From: Andrew Wood <Andrew.Wood@arun.gov.uk>
Sent: 03 August 2020 08:29
To: Planning.Responses <Planning.Responses@arun.gov.uk>
Subject: AB/75/20/PL. AB/76/20/PL

Please find below my objection to the plans AB/75/20/PL. AB/76/20/PL

55A Apartment 3 High St Arundel West Sussex BN18 PAJ

Metres
 55 High Street
 Arundel
 Block Plan 1:500
 A4 Paper

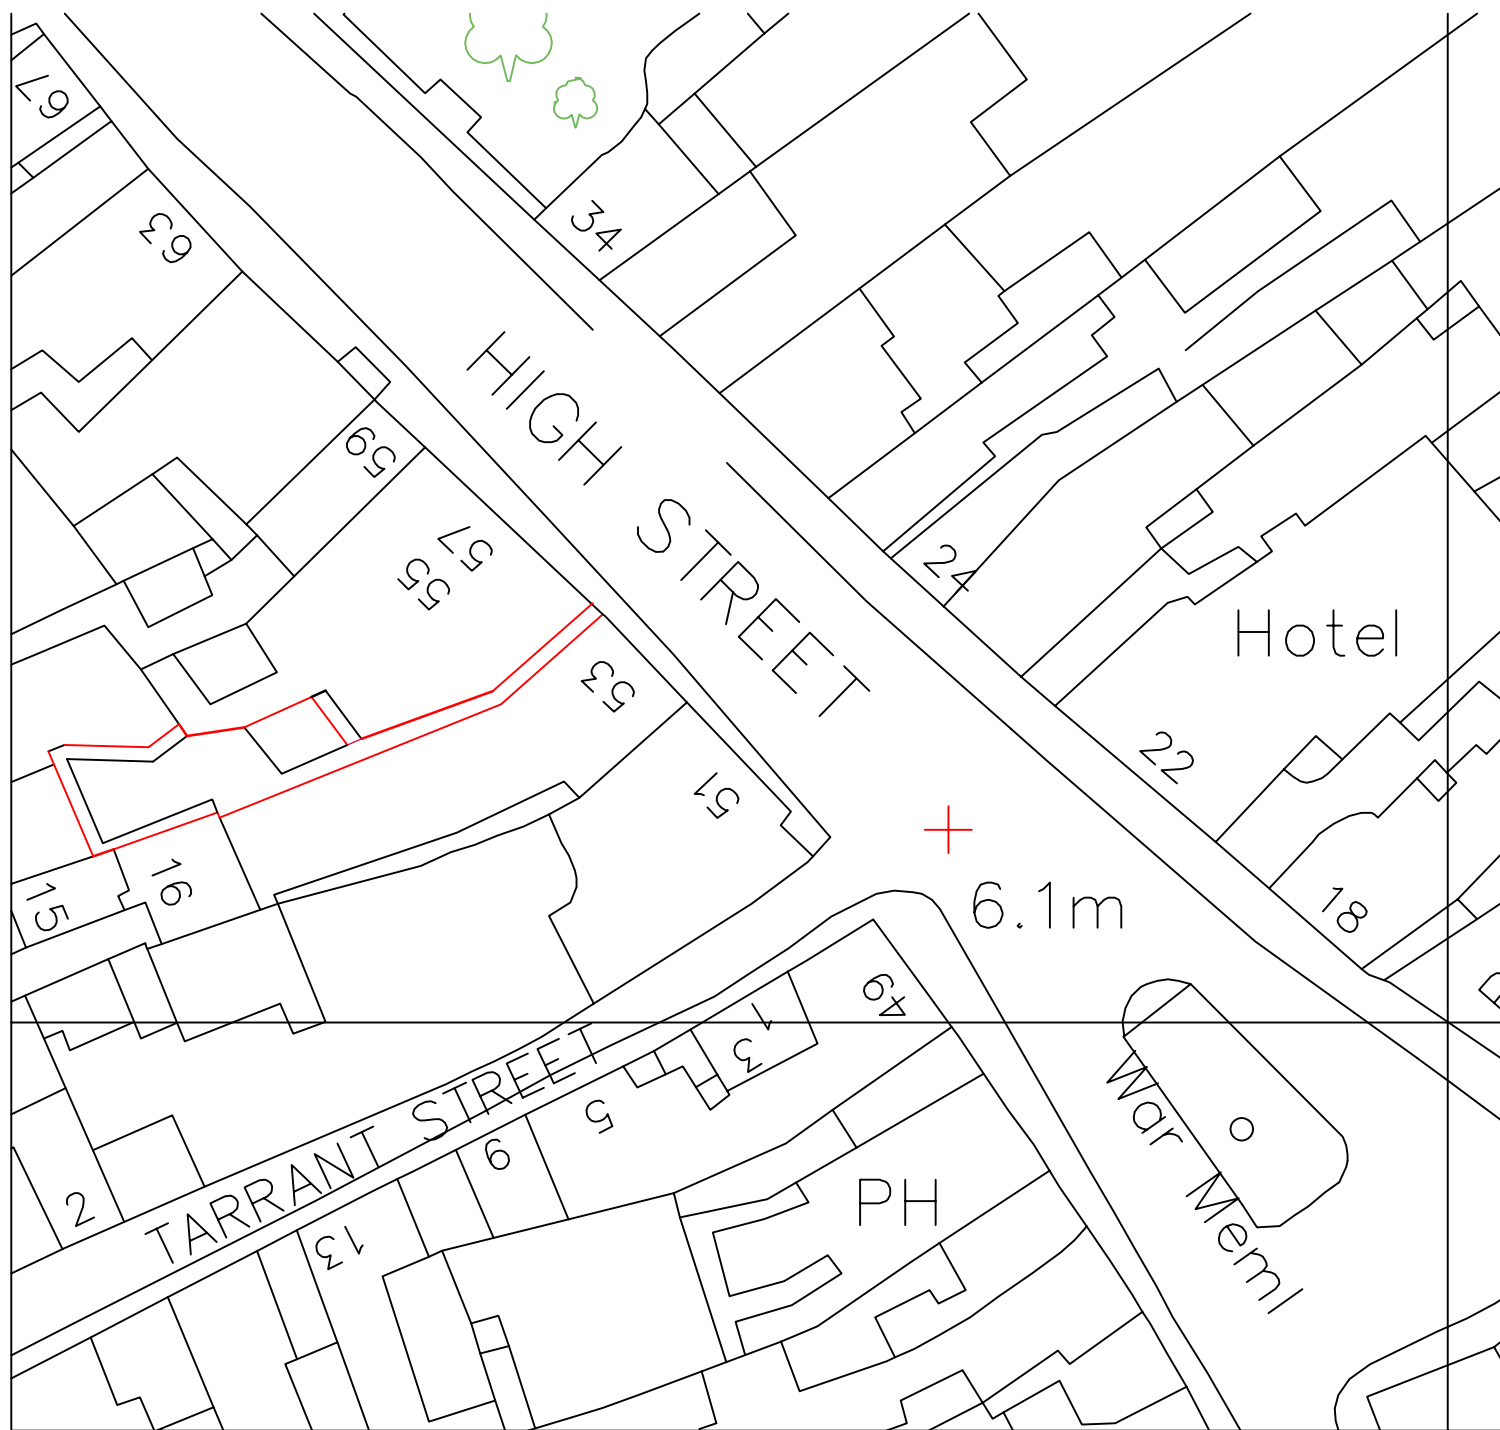
Additionally, Mr Rogers, the applicant's agent has submitted a ground floor plan that claims to be 1:500 scale. A similar size plan was provided by Victoria Holland under AB/48/17/PL which is actually a scale of 1:100. It should be noted that the space surrounding the annex is probably only 1 metre wide. Therefore I doubt the total plot size calculation is correct. This dwelling 3/4s surrounded by high walls almost within touching distance and directly overlooked by 8 dwellings ; which would make for a joyless setting concluding an unequivocal over intensive use of this site.

Proposed Ground Floor Plan

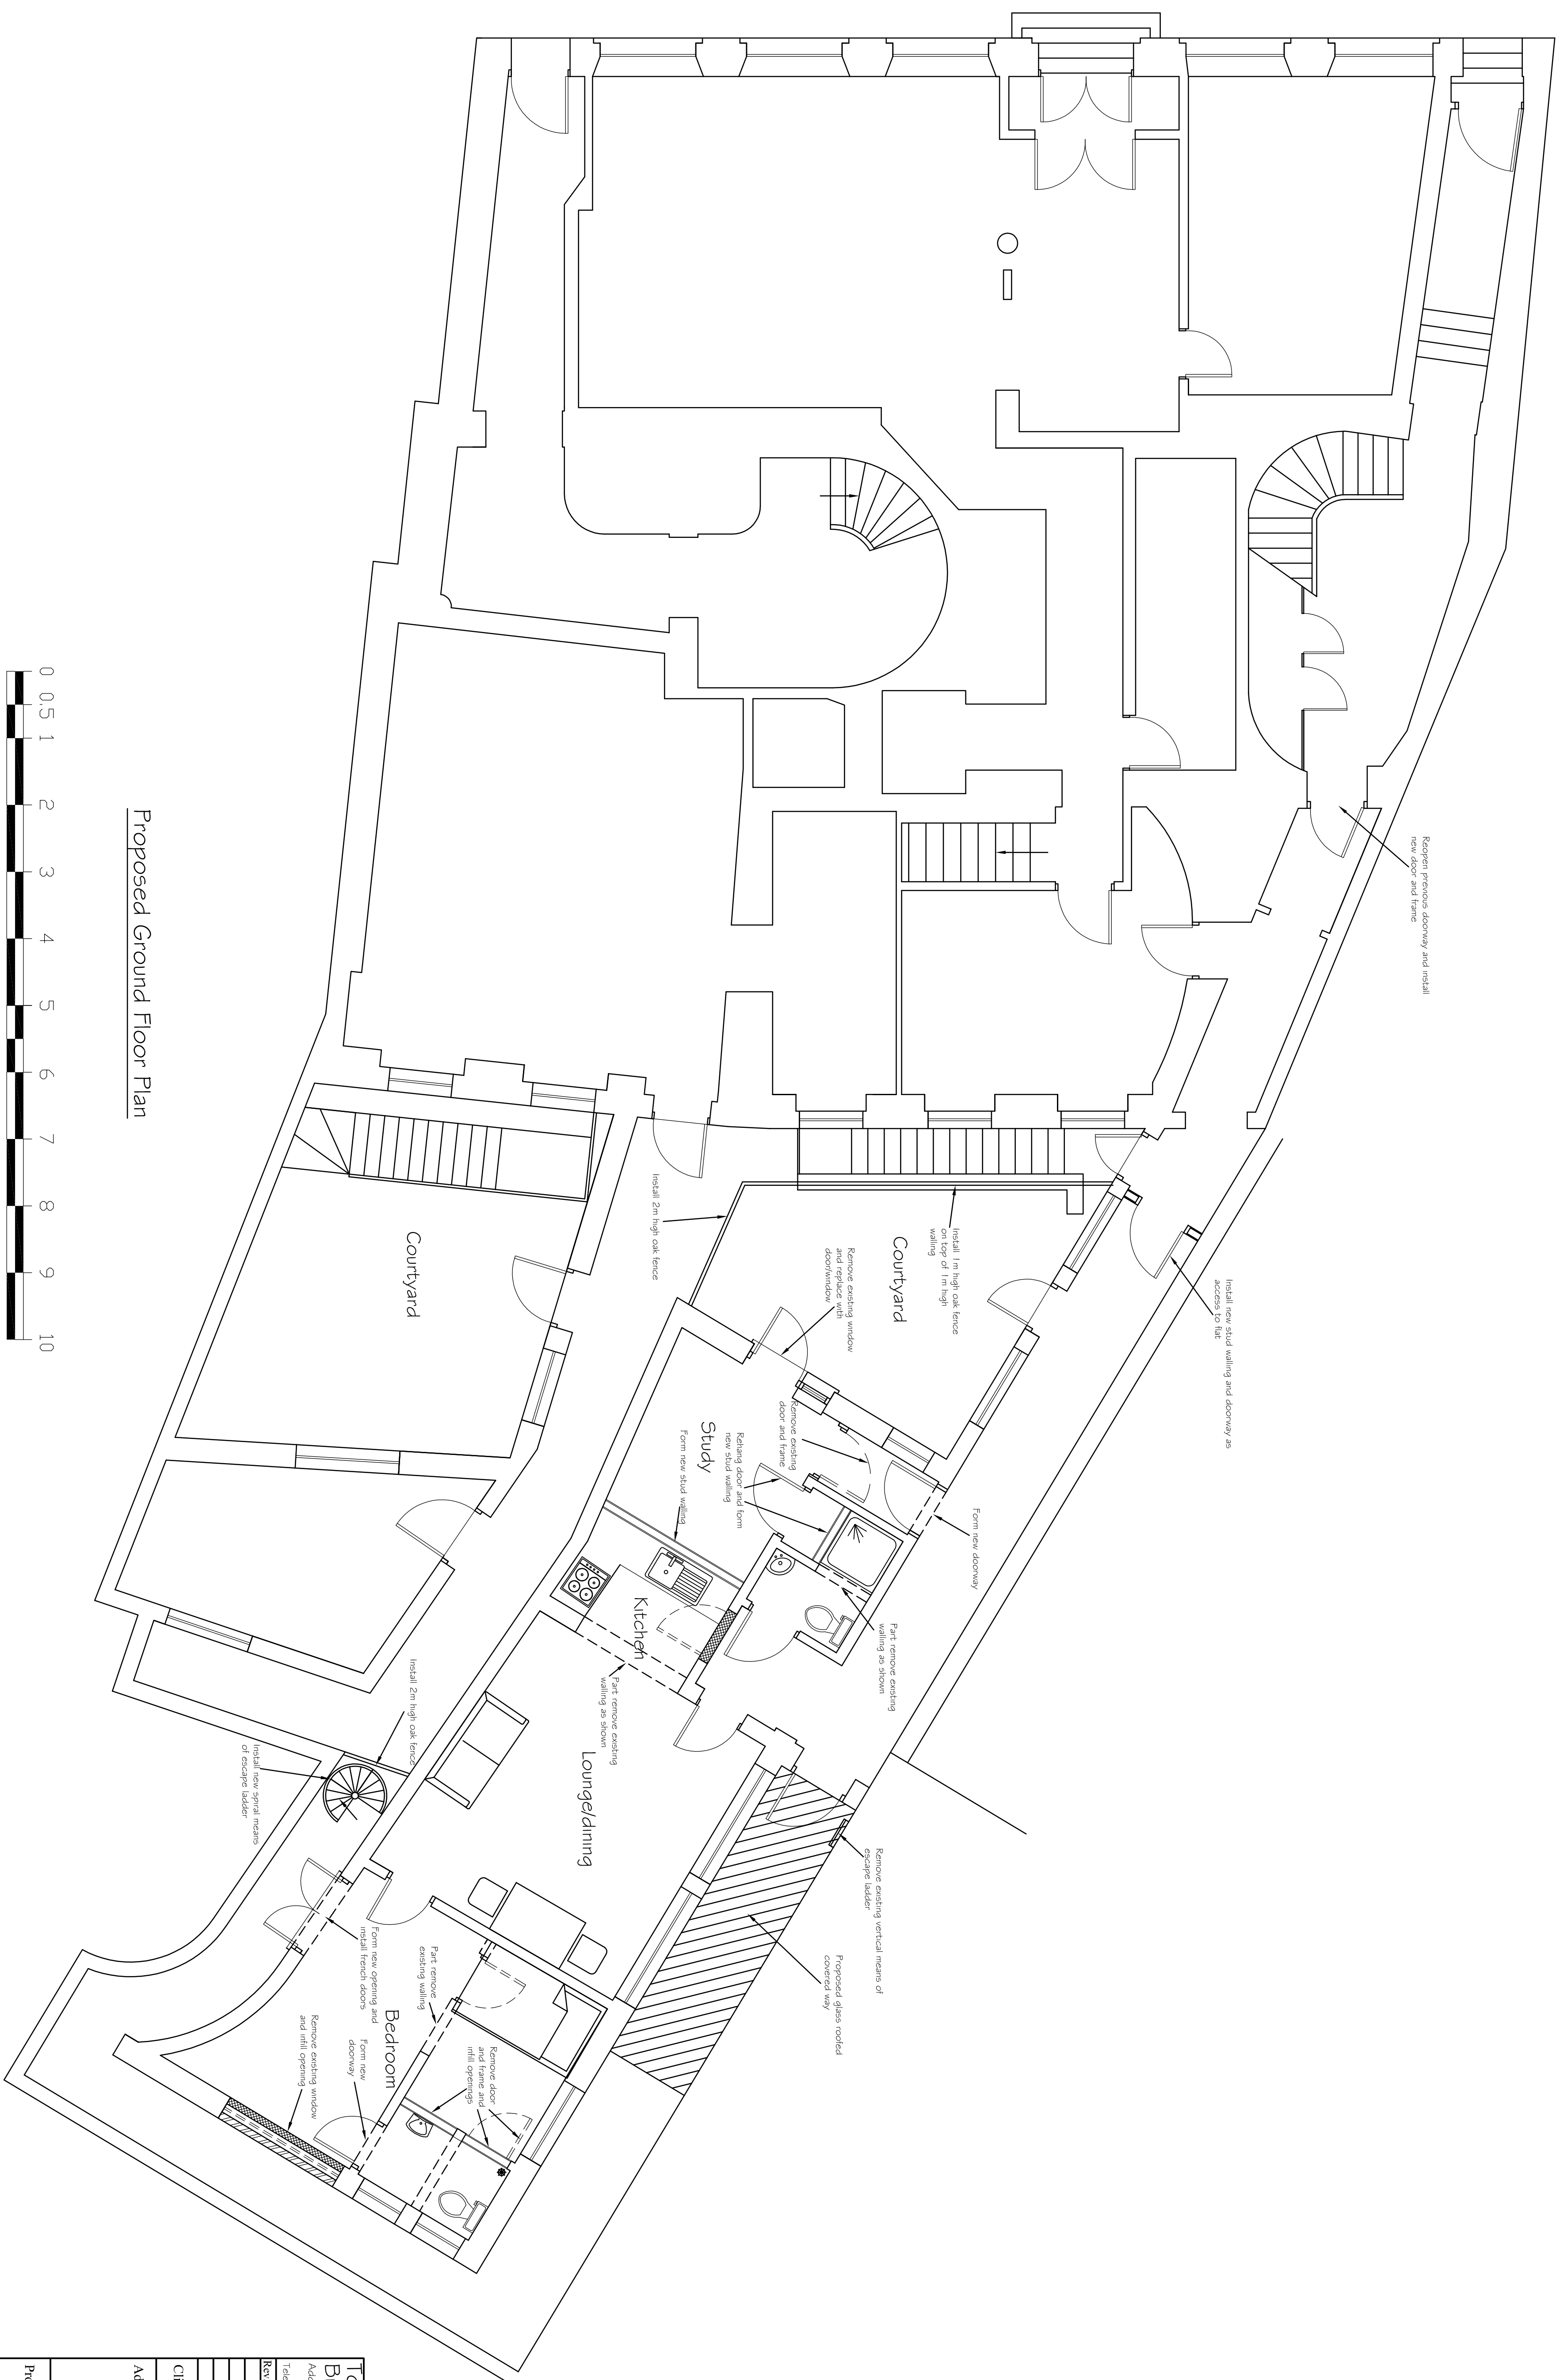
Mr Meredith does not reside in Arundel and has no respect for this building and without warning to the residents or any permission from the Listed buildings department or Arun District Council viewed himself above the law and smashed an opening at ground level in the communal area of 55a under the listed cantilevered staircase. This act was carried out on the 28th May 2020 but I note that on the planning portal application document Part 4, it incorrectly states that works began 20th June 2020 which is a blatant untruth.

Additionally box 6 is incorrect as a partial demolish of an internal wall that contained 2 layers of bricks occurred, with no structural engineers report undertaken where all the evidence suggests that those bricks had been present since 1962. The application and works are negligent in that they do not specify what compensating structural support has been or should be added.

Mr Meredith claims to have sealed up the new doorway entrance when completing the conversion of the flats at 55 and 57 High Street during 2012, but the planning department have discovered that a doorway had existed only prior to 1962 when a planning application was submitted and approved for the opening to be bricked up. Obviously, given that the Natwest Bank deed plans from 1999 and subsequent dilapidations report in 2014 show no doorway, Mr Meredith claims can be proven to be false. Residents of this building before the conversion also testify to the fact that no prior doorway existed [REDACTED]

I would urge the council to reject this planning application and insist that the doorway be sealed as before. To permit unauthorised works sends a signal that anyone who has a duty of care to a historic building can smash through a wall and then apply for retrospective planning permission and get away with it without any consequences especially when they know perfectly well the law in this regard. Indeed the same act was attempted recently on the other side of the building by the Freeholder on 15th June 2020. The confidence that derives from the ongoing works despite an undecided decision is shocking and if left unchallenged sets a new standard for the council.
